Our ref: HA/2022/123884/01-L01
Your ref: P/178/21/OUT
Date: 01 February 2022

**OUTLINE APPLICATION WITH ALL MATTERS RESERVED (EXCEPT ACCESS)
FOR THE CONSTRUCTION OF UP TO 106 NEW HOMES, FORMATION OF ACCESS
ONTO PAGHAM ROAD, NEW PEDESTRIAN AND CYCLE LINKS, THE LAYING OUT
OF OPEN SPACE, NEW STRATEGIC LANDSCAPING, HABITAT CREATION,
DRAINAGE FEATURES AND ASSOCIATED GROUND WORKS AND
INFRASTRUCTURE. LAND WEST OF PAGHAM ROAD PAGHAM**

Environment Agency Position

Figure 6-1: EA Flood Zone Plan showing 1 in 100 & 1 in 1,000 year floodplains

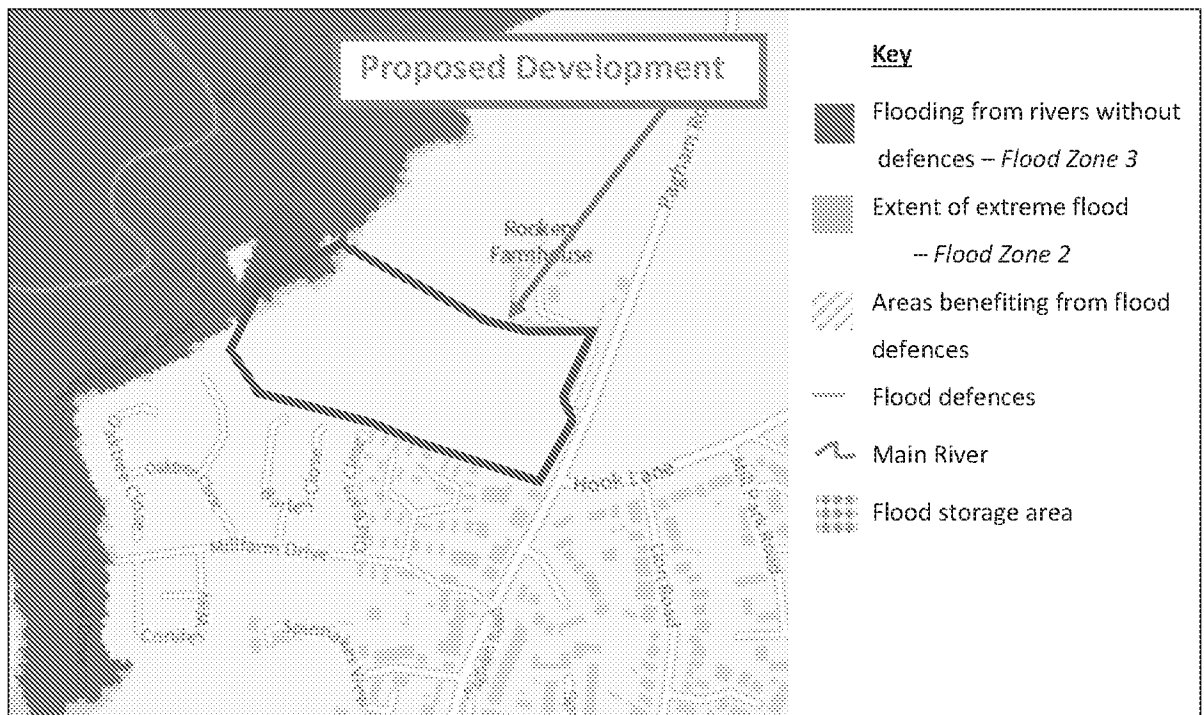
- Correctly identify flood risk at the site Although according to our Flood Map for Planning (Rivers and the Sea) this proposal is mainly located in Flood Zone 1 (low risk), there is a small portion of tidal Flood Zone 2 (medium risk) and 3 (high risk) at the north-eastern side. According to our latest modelling the site could be affected when taking climate change into account and looking at the masterplan some of the proposed residential dwelling will be located within the climate change extent, without any mitigation measure being proposed.

- Take the impacts of climate change into account There is no assessment of the impact of climate change using appropriate climate change allowances (guidance can be found at <https://www.gov.uk/guidance/flood-risk-assessments-climate-change-allowances>)

To overcome our objection, the applicant should submit a revised FRA which addresses the points highlighted above.
